Attachment 1 Rooty Hill Materials Recycling Facility Department's Comments on the EIS

RRD Drawing No:  
**10840-MRF-001**  
PROJECT JOB NO  
EQUIPMENT  
MARK NO  
REV NO  
**L**

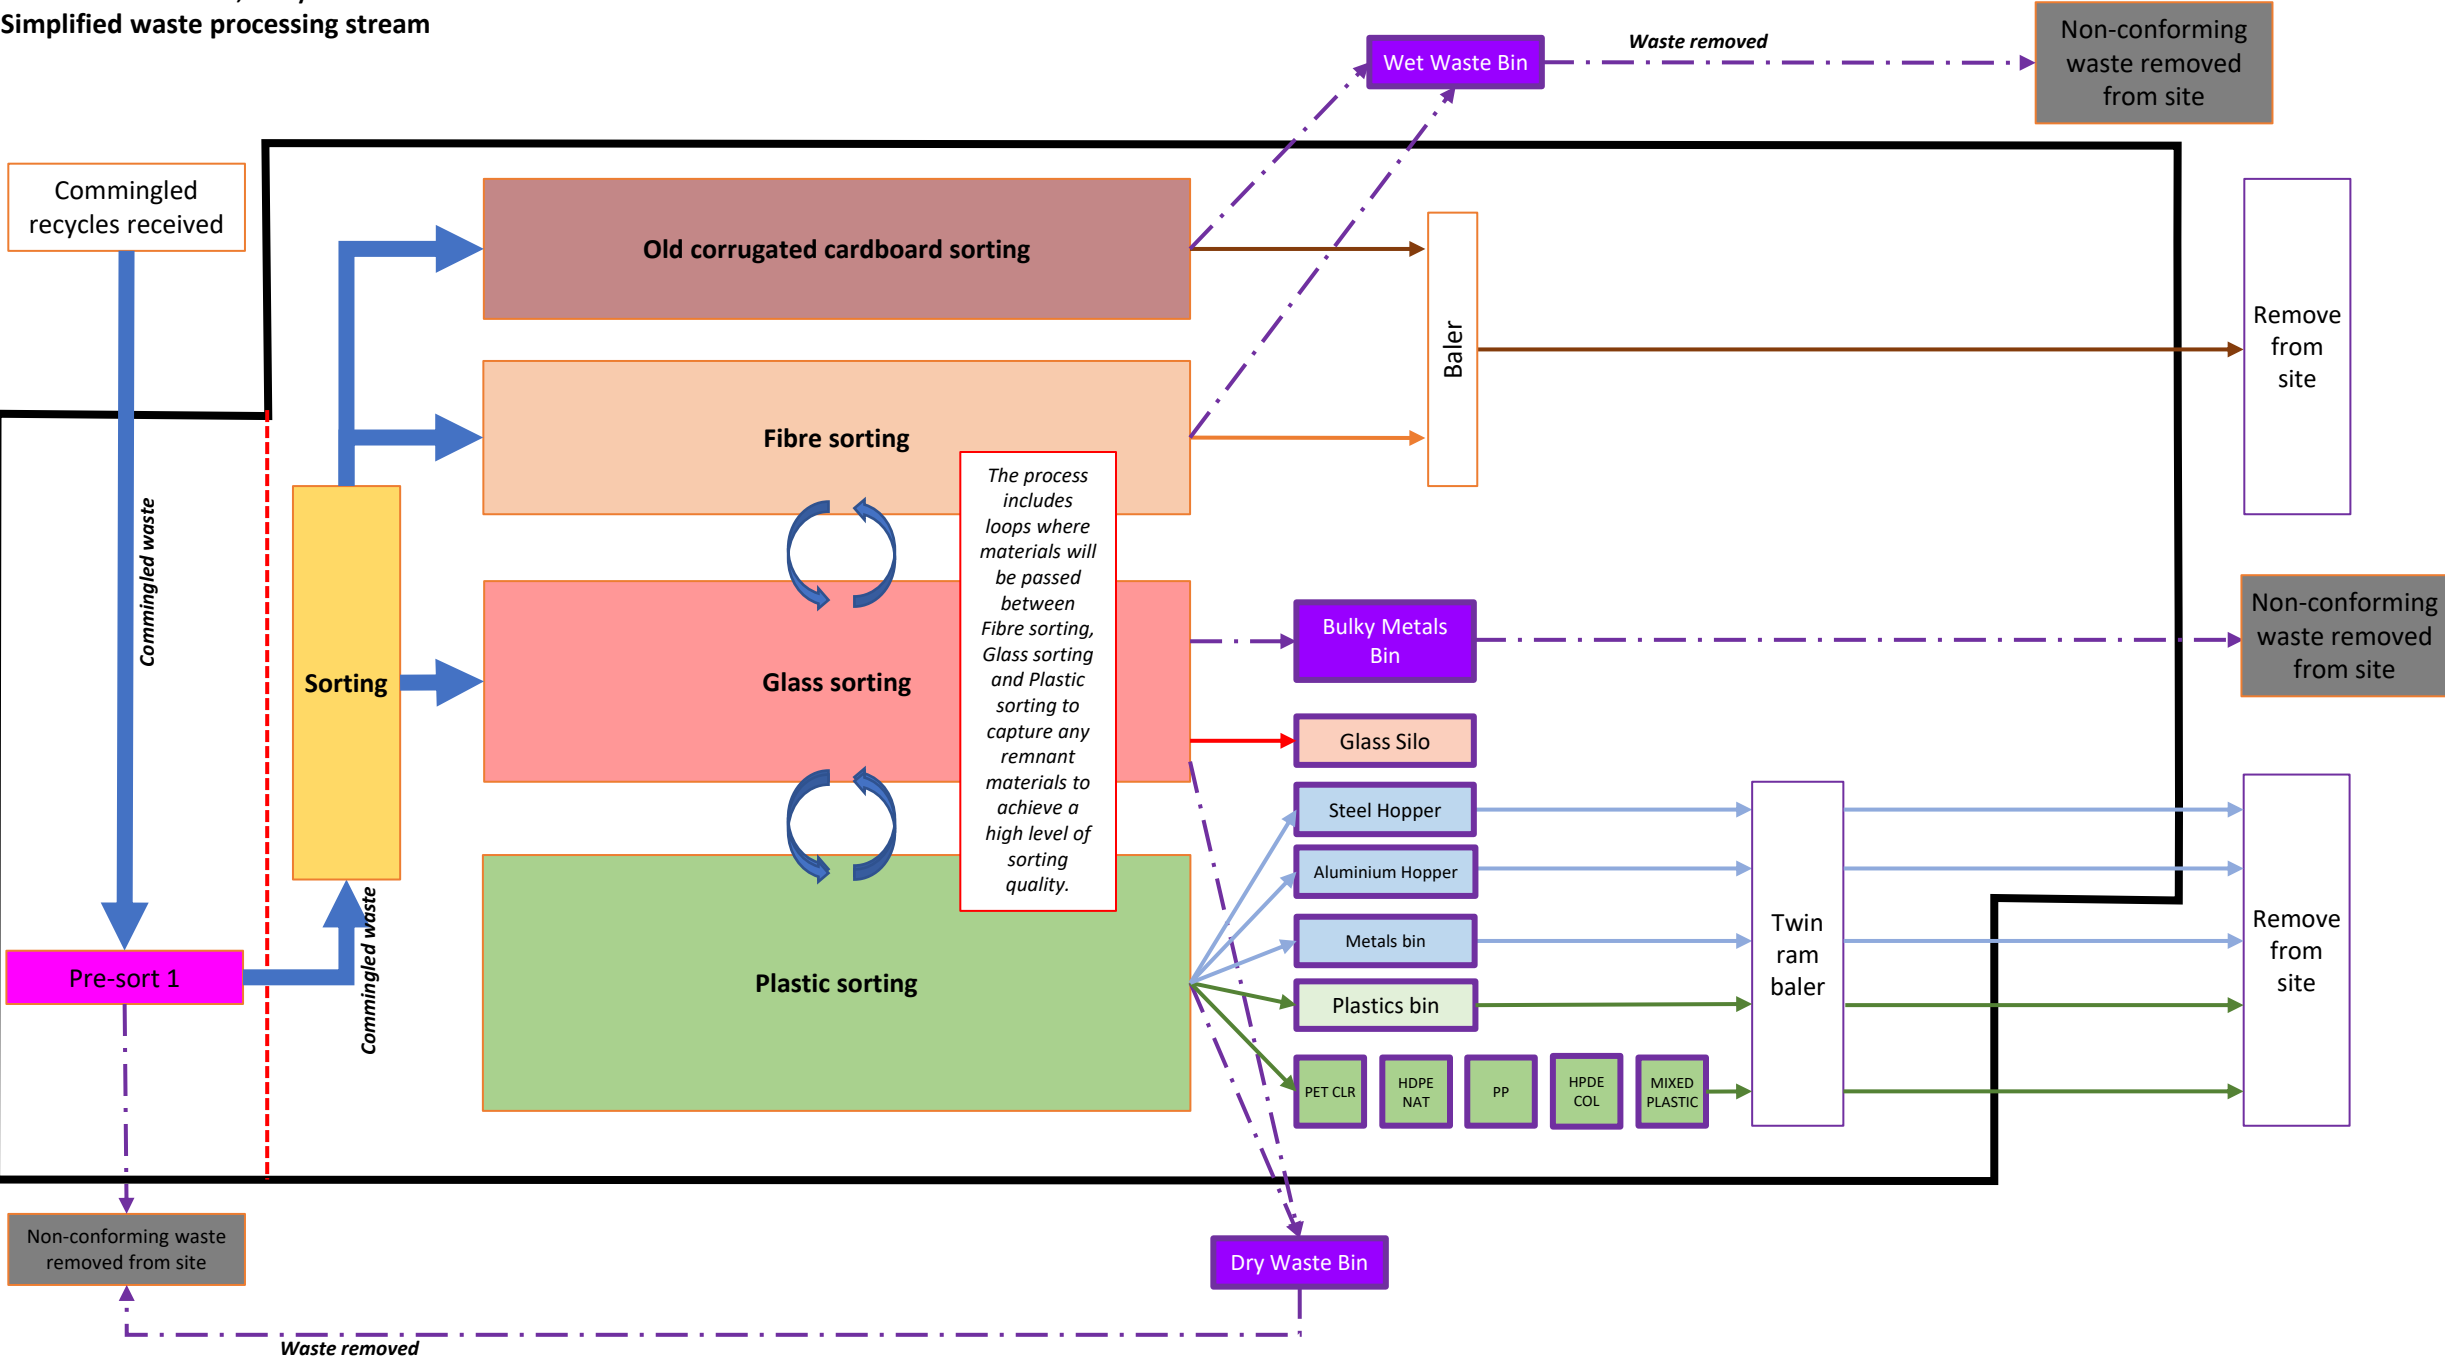
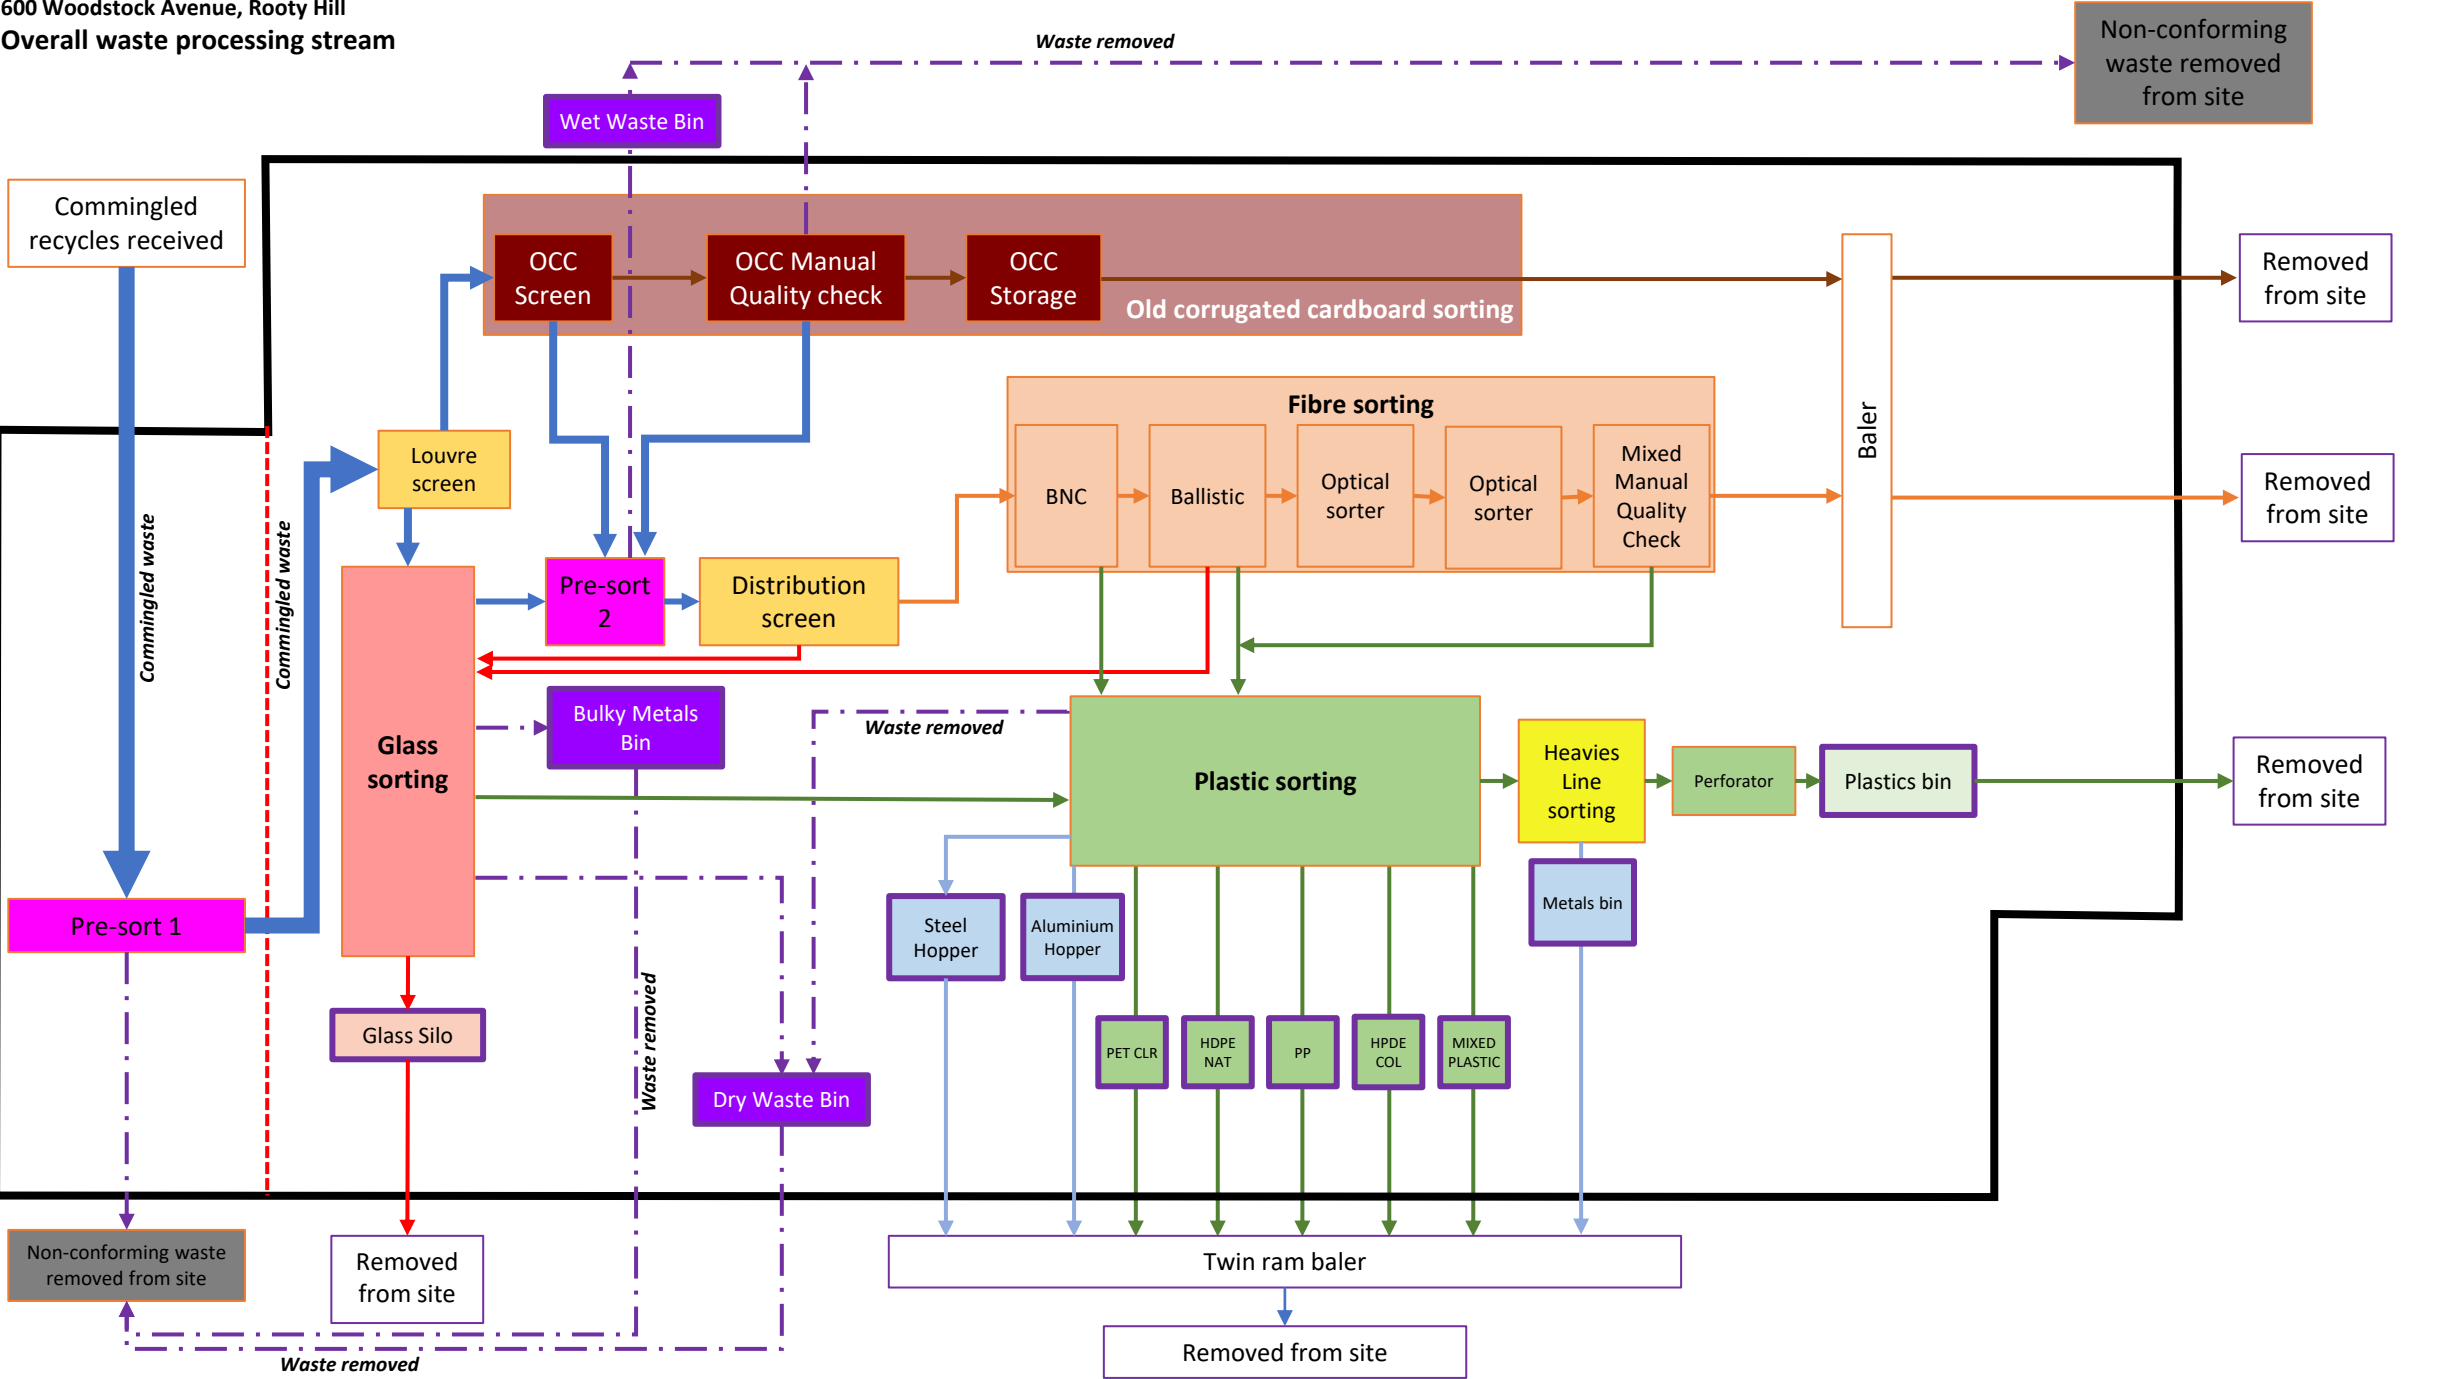
11. Please provide figures 1 to 9 as shown in the Blacktown MRF General Arrangement Plan (10840-MRF-01, Rev L).
12. Section 5.2.3.3 of the WMP states that 'dry waste will be held in a bunker conveyor and baled for distribution to the PEF plant. Wet (putrescible) waste will be contained in a sealed 30 m³ compactor bin for delivery to landfill'. Please clarify:

Figure 4 Kerbside receival bays

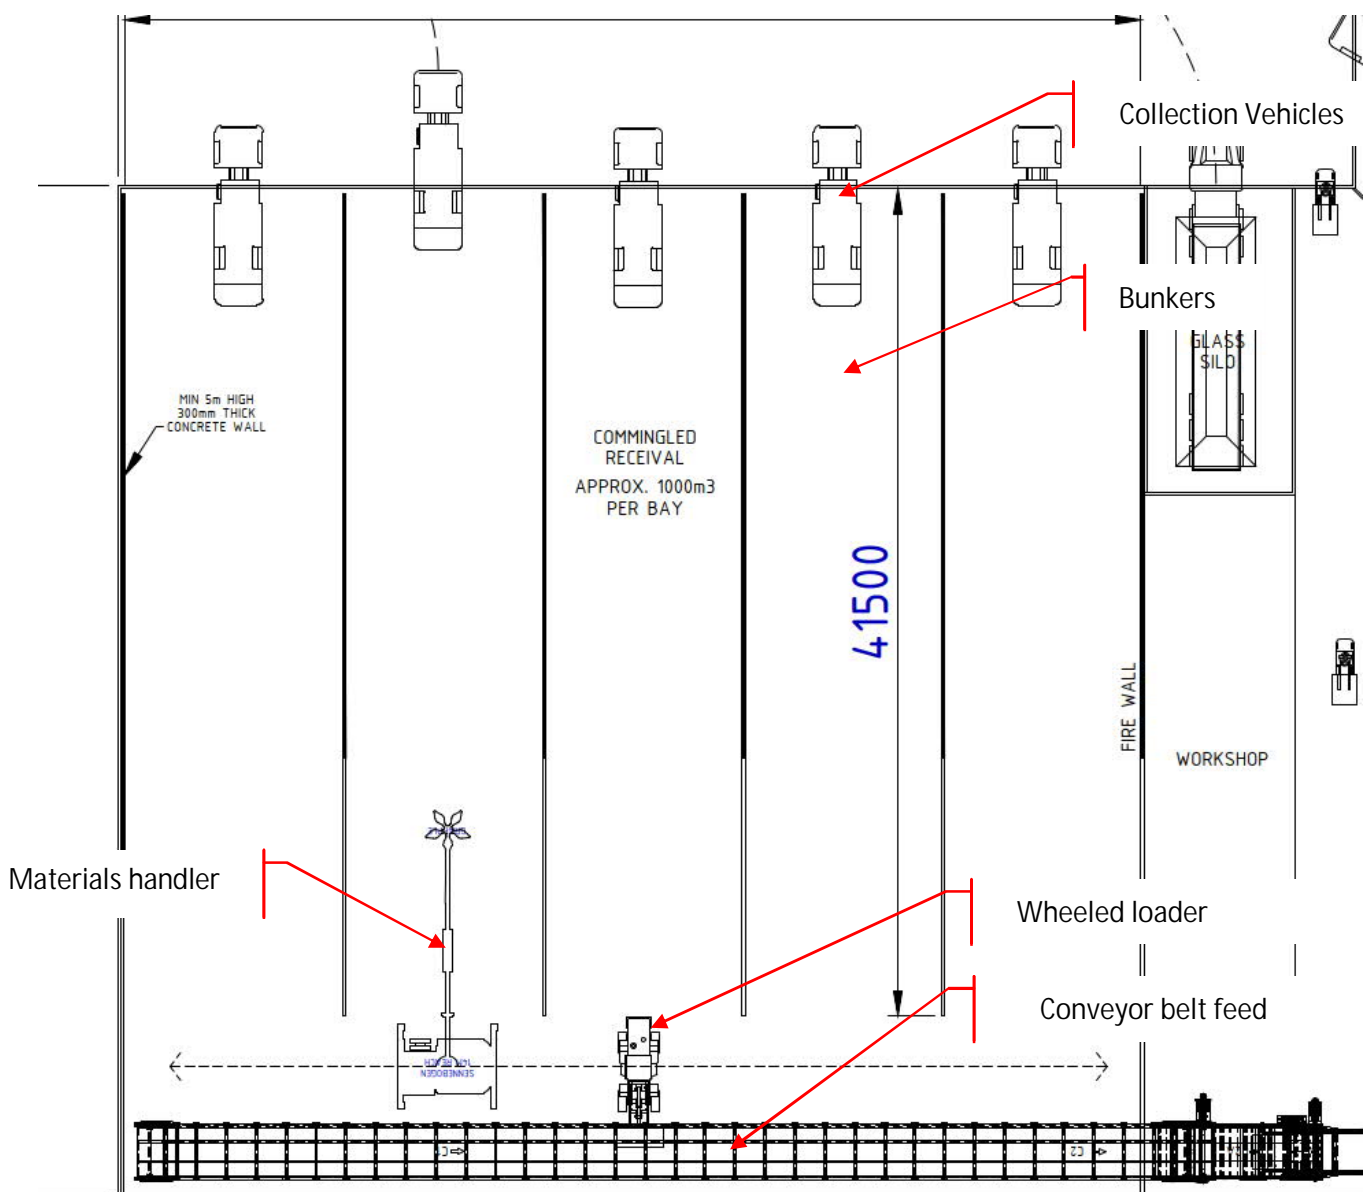
4. Section 5.2.3.3 of the WMP advises that 'incoming materials will be inspected in the five bays in the main receival hall. Loads suspected to contain hazardous material will be isolated to a single receival bay until they can be inspected and photographed'. Please clarify if the single receival bay is one of the six commingled receival bays. If so, please clarify:

6. Section 5.2.2 of the WMP states that 'the contents of the vehicles will be discharged into one of five bunkers on the southern side of the facility. A grab arm will remove any hazardous or undesirable items before a wheeled loader pushes the stockpiles onto a conveyor that leads into the sorting and processing facility'. Please clarify:

- (a) locations of the five bunkers and grab arm
 - (b) how co-mingled waste will be moved from trucks to the bunkers
 - (c) where the hazardous or undesirable items will be stored.

Figure 5 Location of bunkers, balers and storage areas

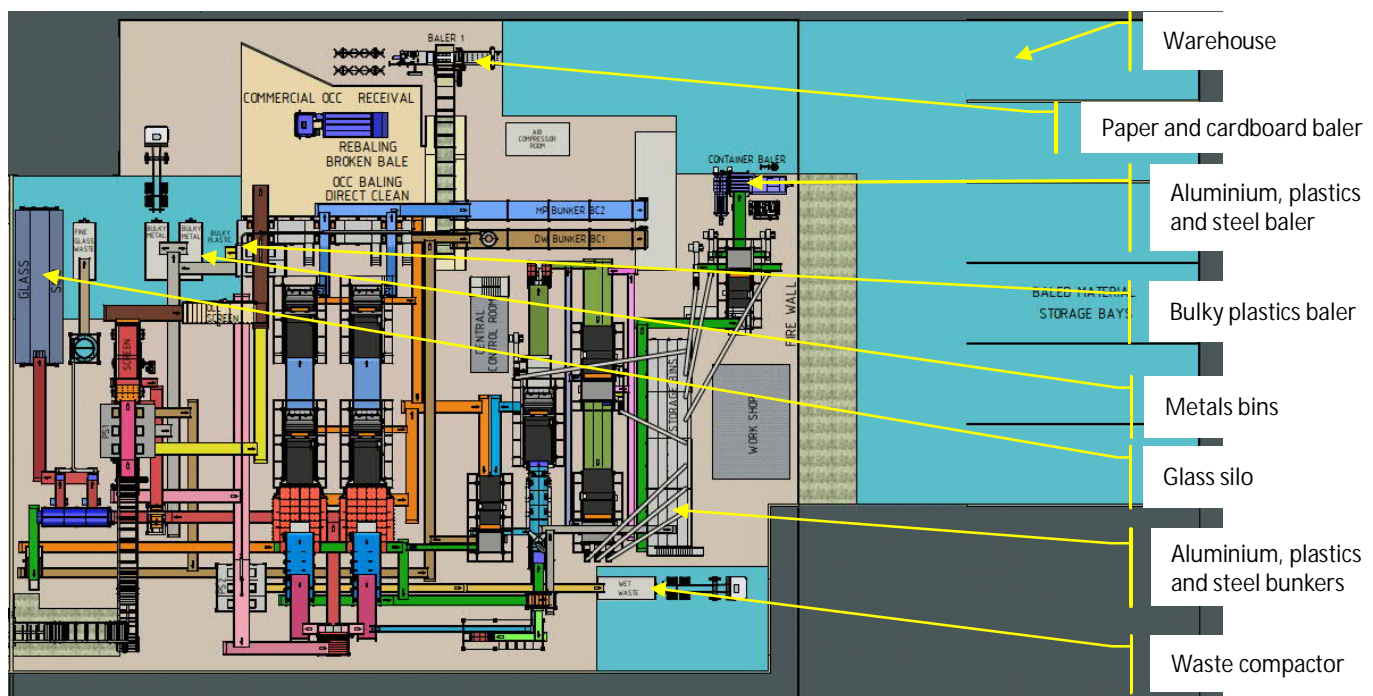
8. Section 5.2.2 of the WMP advises 'baled product will be sent to the storage warehouse from where it will be loaded into articulated heavy vehicles for transport to markets'. Please clarify the location of the storage warehouse, the largest size of the articulated heavy vehicles, and frequency of delivering baled products to markets.

10. Table 20 of the WMP does not include the quantity recovered for each type of material. Please clarify. Also, please clarify whether waste listed in Table 20 means dry and wet waste collectively as described in Section 5.2.7.
